Re: Dendrobium Mine Extension Project (SSD 8194) – Response to Submissions

I refer to your email dated 19 February 2020 inviting WaterNSW to provide comments on the Response to Submissions (RTS) document for the Dendrobium Mine Extension Project (the project). WaterNSW appreciates this opportunity and has undertaken a detailed review of the RTS.

Figure 1: Stream Mapping (Source: MSEC, 2019b)

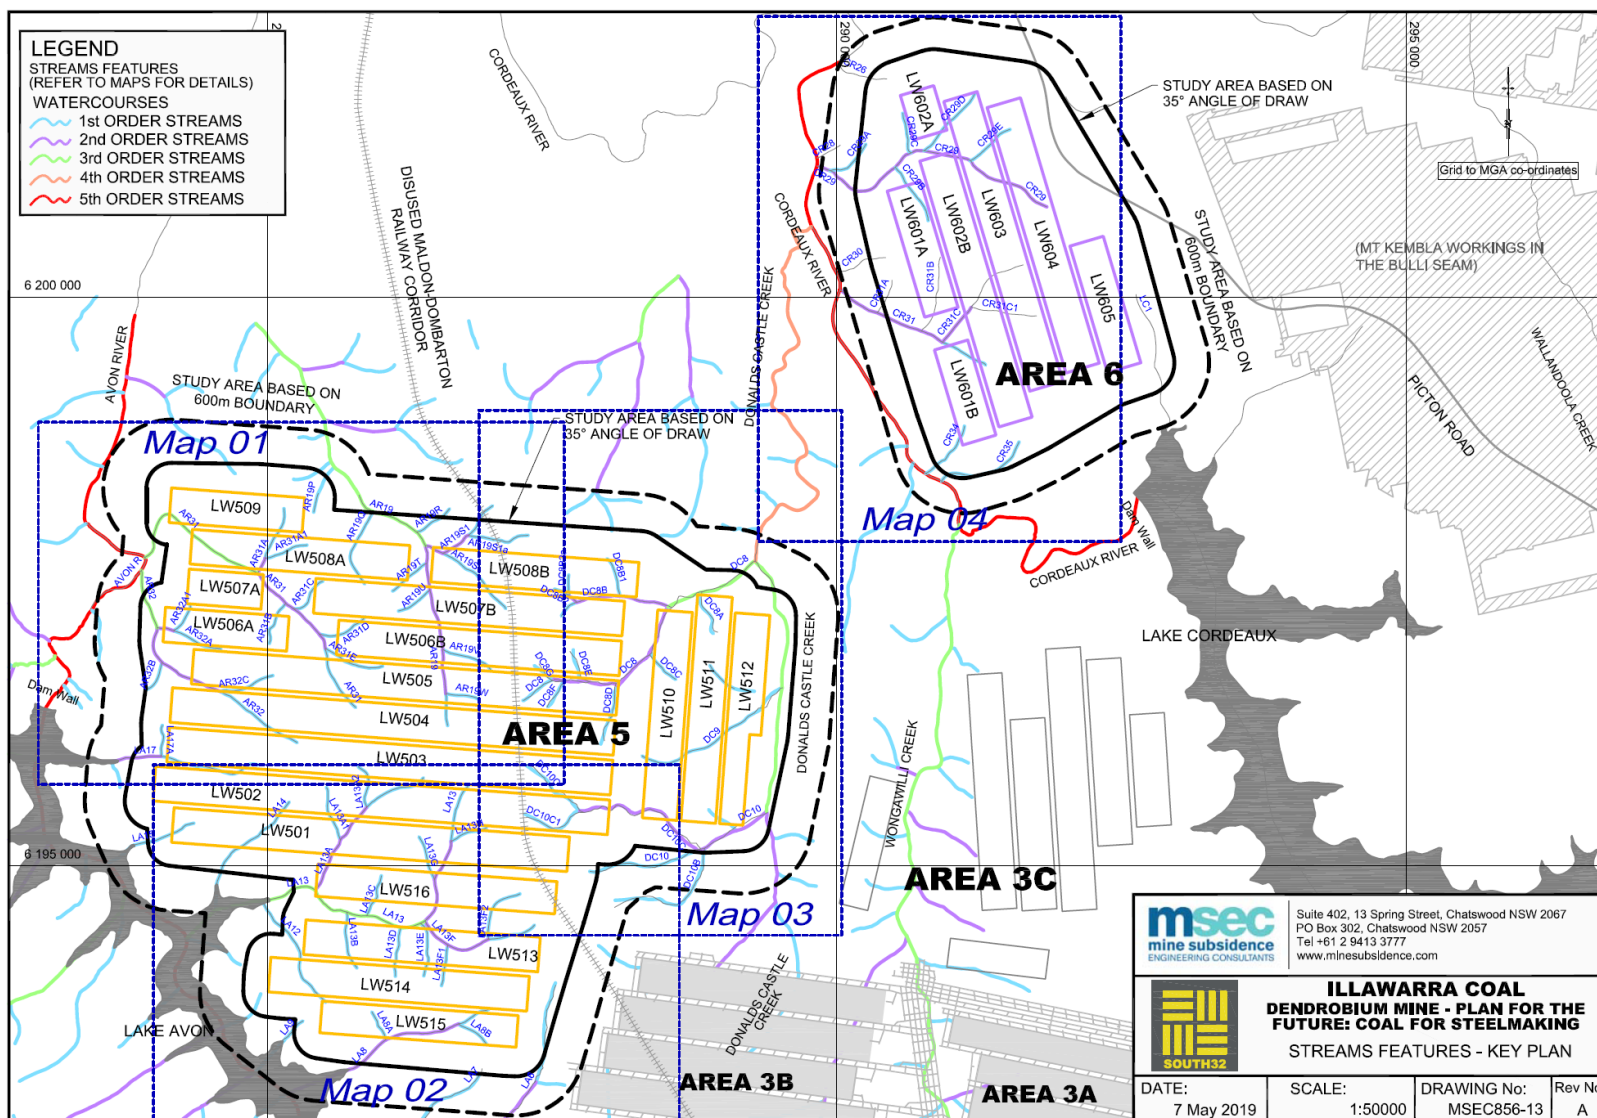
In addition, it appears that with minor adjustments to the mine layout, it is possible to avoid mining directly under second and third order watercourses, for example:

- shifting the western end of LW509 by approximately 150 m to the east,
- shifting the western end of LW516 by approximately 100 m to the east, and
- shifting the northern end of LW510 by approximately 400 m to the south.

Figure 1 Maximum predicted vertical subsidence versus longwall void width

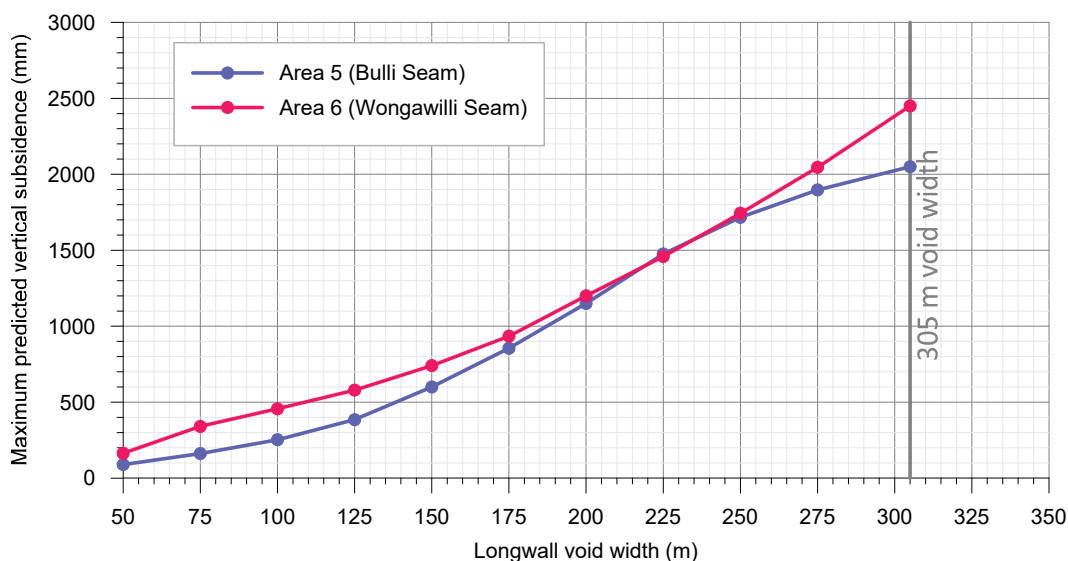
WaterNSW notes that the RTS makes an unsubstantiated statement that adverse environmental impacts are still anticipated for reduced longwall widths down to approximately 150 metres. No reports or data are provided to support this claim.

South32 should be required to provide detailed information on the environmental risk profile from increasing incremental widths of longwalls (e.g. 100 metres, 150 metres, 200 metres and 250 metres). This information is critical to understand the implications of reduced longwall widths on depressurisation and predicted surface water losses from Sydney's drinking water catchment.
